CITY OF ALBUQUERQUE

June 16, 2023

Re: New Office/ Warehouse Building
7421 Snaproll St. NE
30-Day Temporary Certificate of Occupancy
Transportation Development Final Inspection
Architect's Stamp dated 02-16-22 (D17-D003AA7)
Certification dated 06-06-23

3 PARKING SIGNS

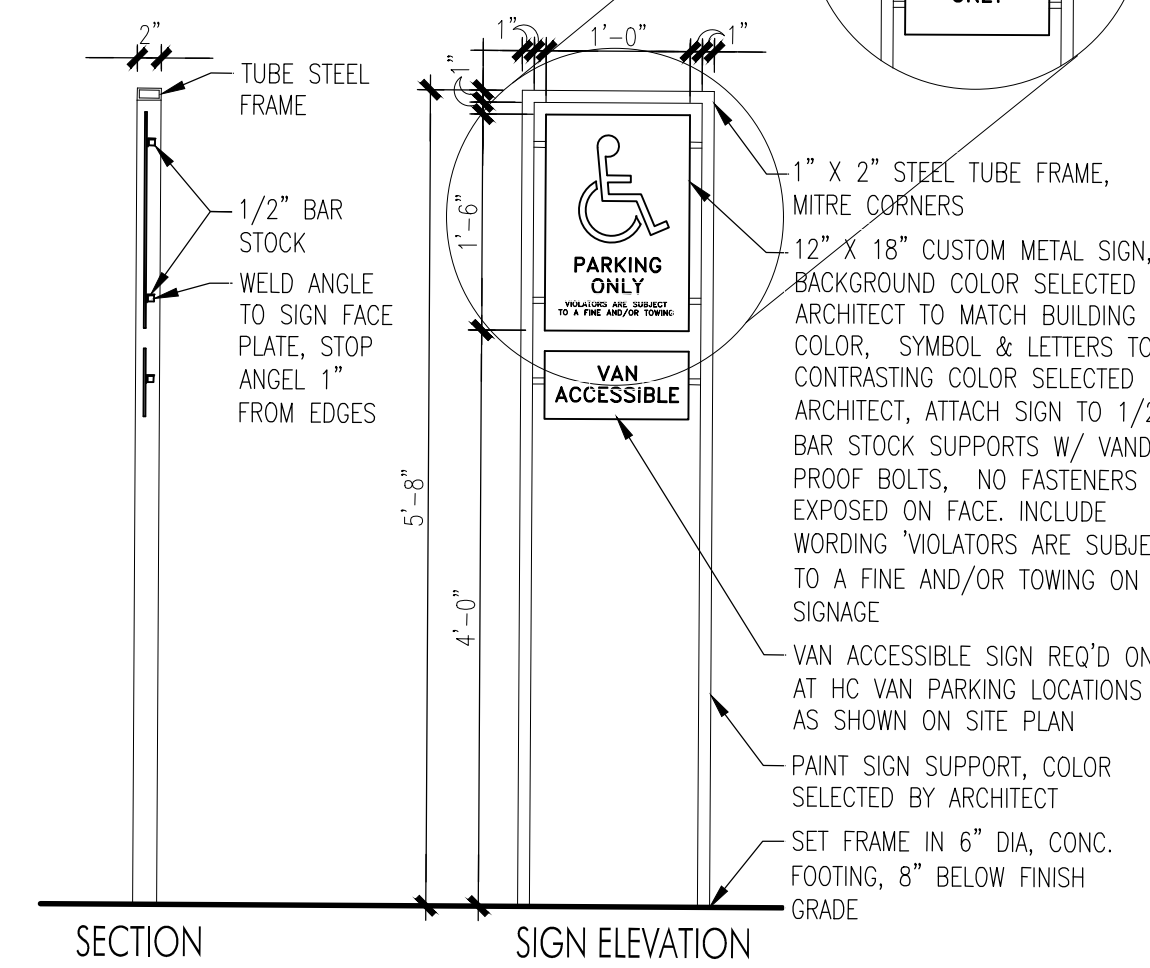
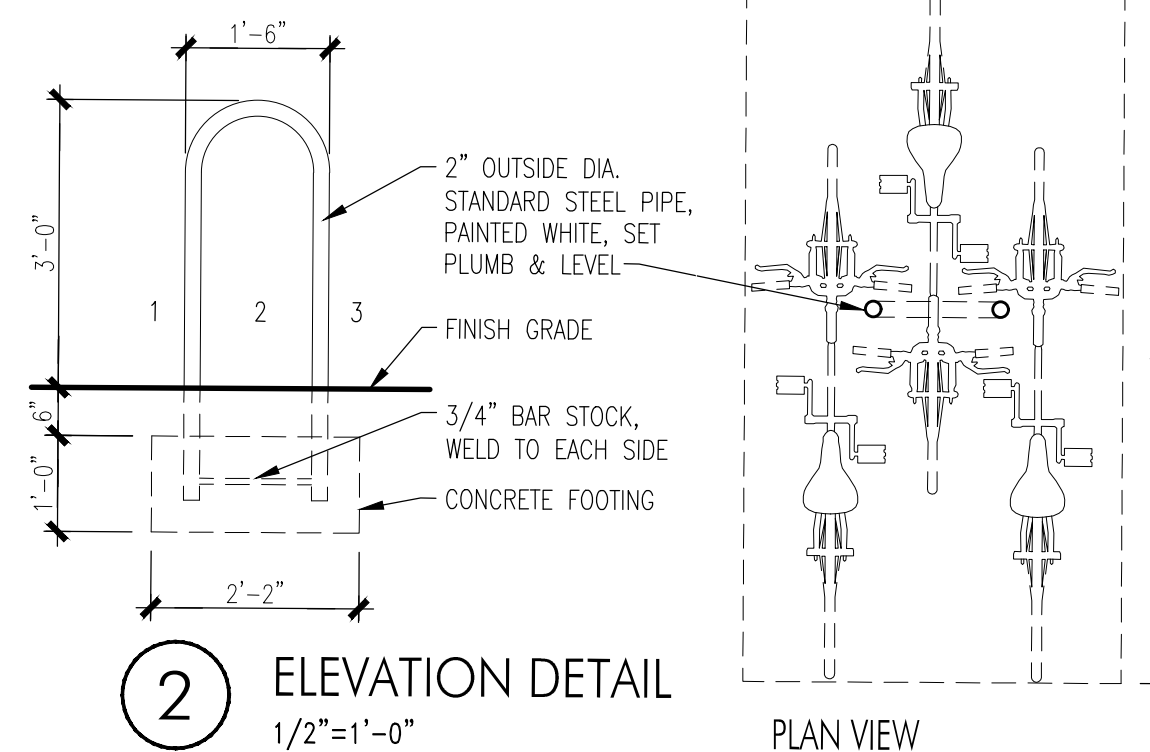
- The ADA accessible parking sign must have the required language per 66-7-352.4C NMSA 1978 **"Violators Are Subject to a Fine and/or Towing."** Please call out detail and location of signs.
- The pavement marking "MC" should be shown in the opposite direction for motorcycles entering the parking space.
